# HILLS SHOWGROUND STATION PRECINCT DEVELOPMENT (SSD-9653)

THE HILLS SHIRE COUNCIL REVIEW OF SSDA SUBMISSION

THS Council Response to SSD-9653, 10 December 2019, Reference FP223		WSP Response	THS Council Comments to WSP Response
<b>FLOODING AND STORMWATER MANAGEMENT</b>			
1	Flooding and overland flows within the subject site under developed conditions should be demonstrated in addition to existing conditions within the precinct and Cattai Creek. Consideration should be given to orderly development and identification of any constraints in relation to the existing and proposed stormwater network required to be provided. As per Council's Showground Precinct DCP, stormwater runoff must be treated on the development site before it discharges to a public drainage system.	Hydrologic and hydraulic modelling was beyond the scope of the IWCMS, however other recent studies undertaken as part of the Metro works were reviewed. The Design Report for North West Rail Link Operations, Trains & Systems Package No.2109 Package Title WAD Package 9 – Showground Road at New Precinct Street B (August 2016) indicates that the recently constructed on site detention basin on the north western boundary has

Figure 4-1 OSD basin indicative locations

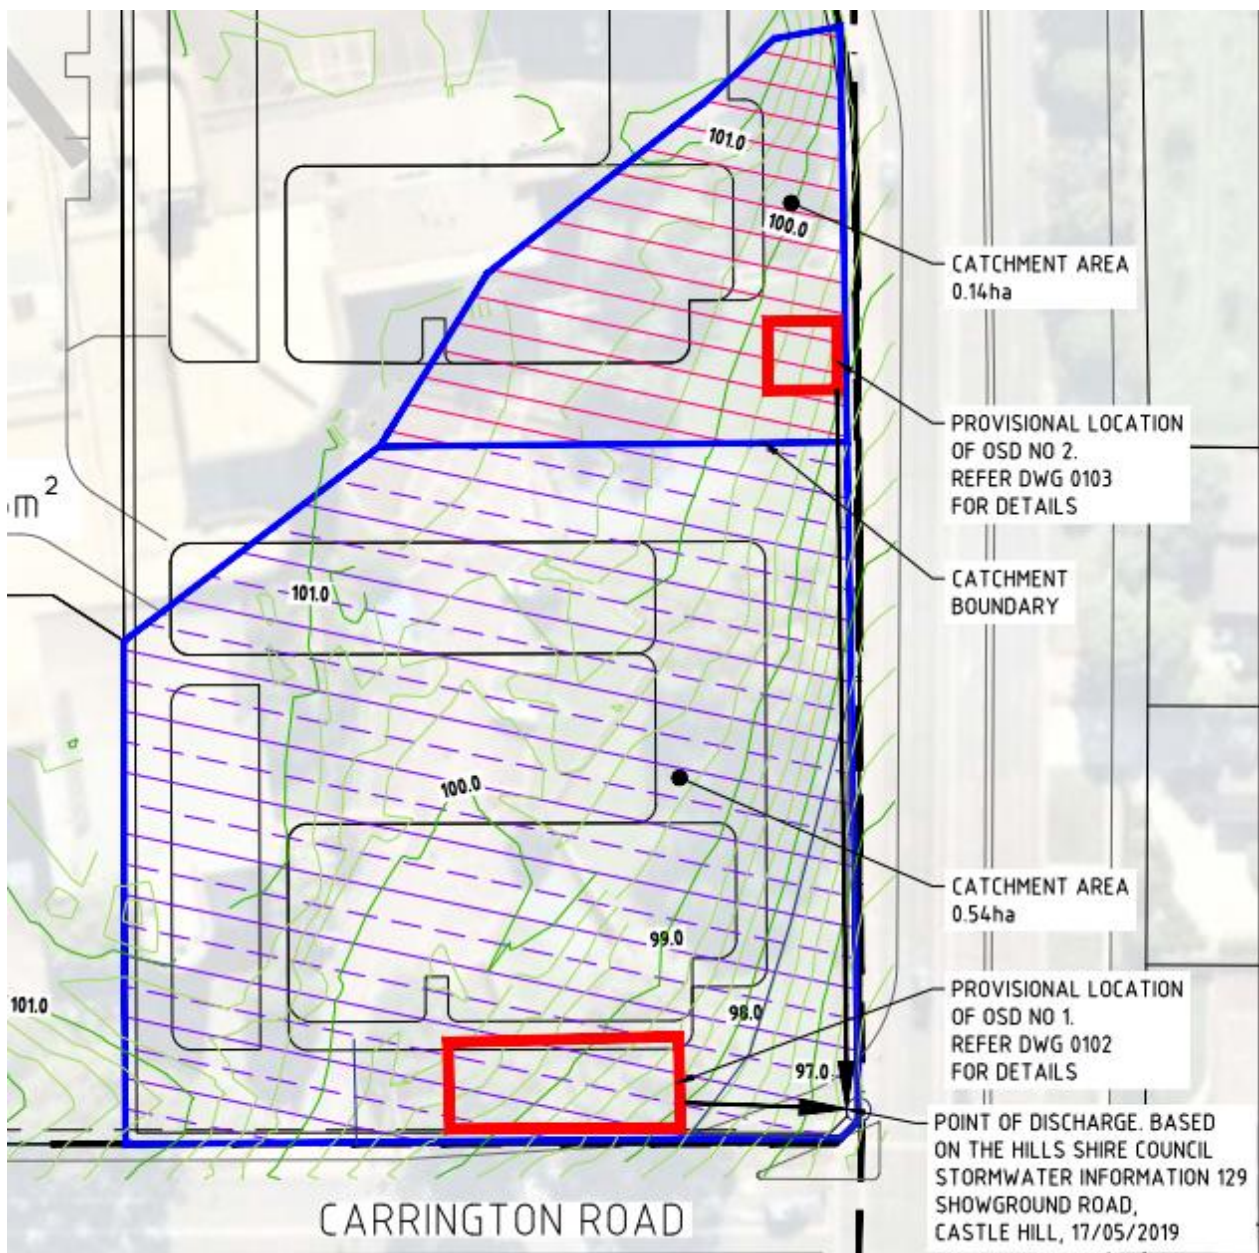
4	Flows draining from the eastern portion of the site to the intersection of Showground Road and Carrington Road are to consider the RMS proposed stormwater network upgrades in that immediate locality.	The Design Report for North West Rail Link Operations, Trains & Systems Package No.2109 Package Title WAD Package 9 – Showground Road at New Precinct Street B (August 2016), Section 6.4.3.4 states "The design has ensured that all runoff from the road surface and future development areas are captured and directed to OSD basin and proposed Carrington Road drainage systems." The Carrington Road drainage system is the eastern most section of the project. <i>Refer to Figure 6.2 of the report</i>	<b>Not addressed.</b> Under existing conditions, the easternmost section of the Hills Showground Station Precinct drains towards the intersection of Showground Road and Carrington Road. In the developed scenario, the eastern section of Precinct East will also drain towards the same junction. Section 6.4.3 of the NWRL Design Report Package No. 2109, however, did not discuss how this area drains under both existing and developed scenarios. Section 3.2.2 of the IWCMS discussed about the existing drainage of this area but there was no mention in Section 4 of IWCMS about the drainage of the area under developed conditions. The IWCMS should state that drainage of the eastern section of Precinct East will drain towards the drainage system at the intersection of Showground Road and Carrington Road and consideration be given to the potential upgrades undertaken by RMS on the drainage system in consequence of the civil and any drainage upgrading works completed within Showground Road.

Figure 4-8 Indicative schematic of bioretention (cross section)

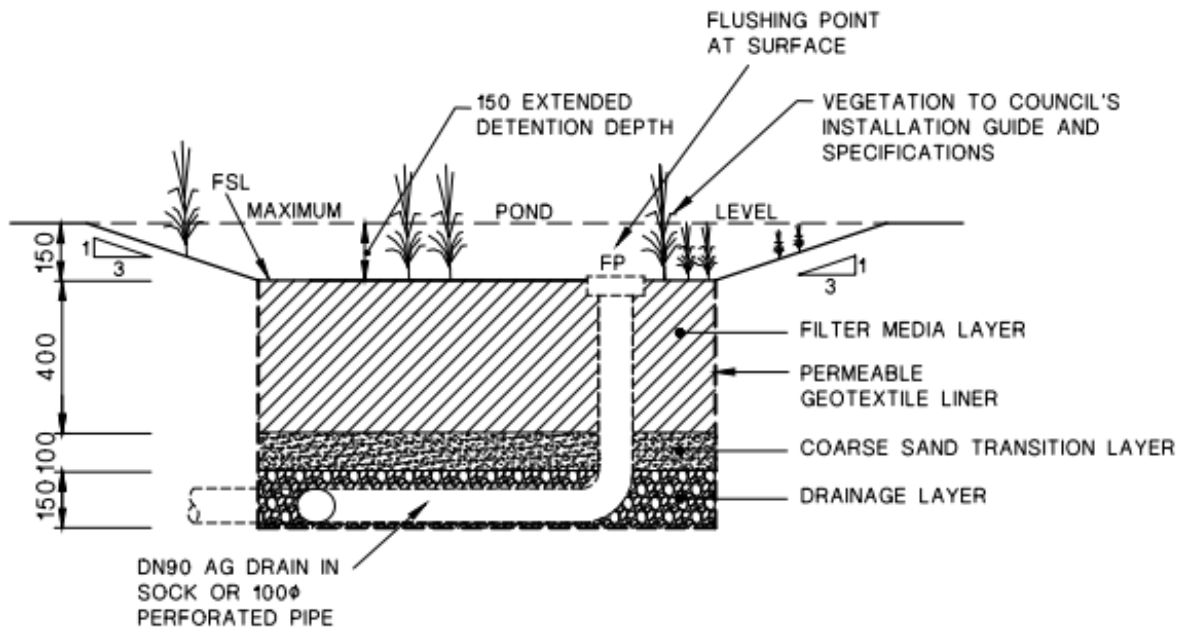
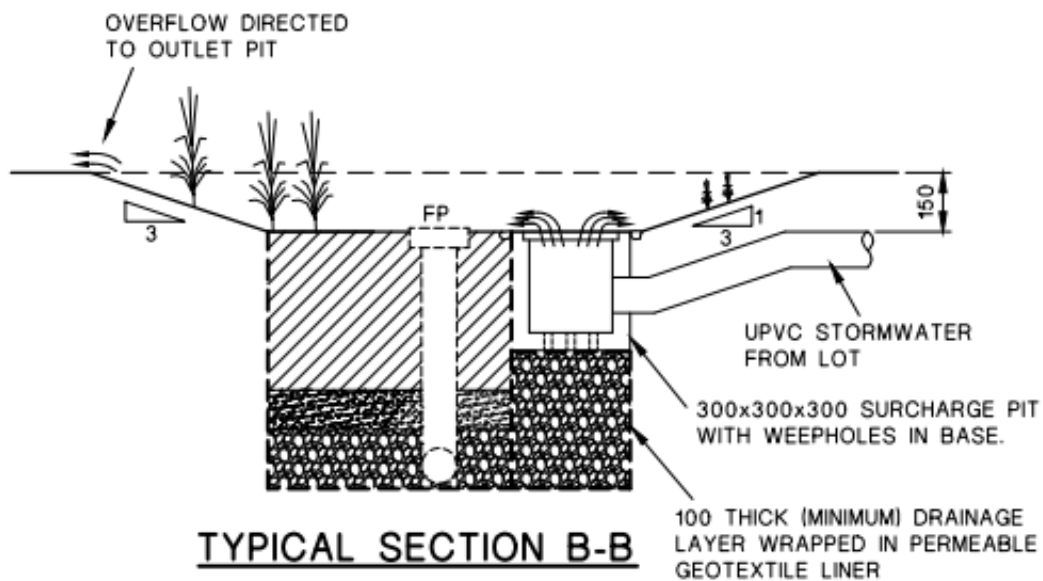
14	In reference to Appendix A, A3.4 Bioretention Measures of the Integrated Water Cycle Management Strategy, the bioretention parameters modelled in MUSIC need to be amended for the concept proposal. Specifically, any bioretention system is to be lined and contain an underdrain. Additionally, review and clarification or amendment is required in regard to the nominated value of 'Unlined Filter Media Perimeter' being 0.01m. An amended MUSIC model is required to demonstrate achievement of pollutant reduction targets for the proposed development.	The proposed bioretention includes a perforated pipe at the base of the filter but the proposed bioretention swales are unlined. We note that Council development controls don't require lined grassed swales or lined bioretention swales. RMS Water Sensitive Urban Design Guide (May 2017) Section 3.4.2 states "Design of bioretention swales must consider the potential for infiltrated stormwater to impact on surrounding infrastructure which can be avoided by using such techniques as installing an impervious membrane across the shared boundary with the element and/or having them installed with a slotted pipe at the base to convey any excess water." The proposed IWCMS includes a perforated (slotted) pipe.	<b>Not addressed.</b> Due to salinity and groundwater levels in western Sydney, Council requires all bioretention system to be lined with impermeable liners all around i.e. base, walls/perimeter (refer attached Council biofiltration fact sheet). A 100 mm perforation subsoil drainage pipe also needs to be provided. Table A3.4 of Appendix A of IWCMS need to be updated to reflect the required properties of biofiltration systems.
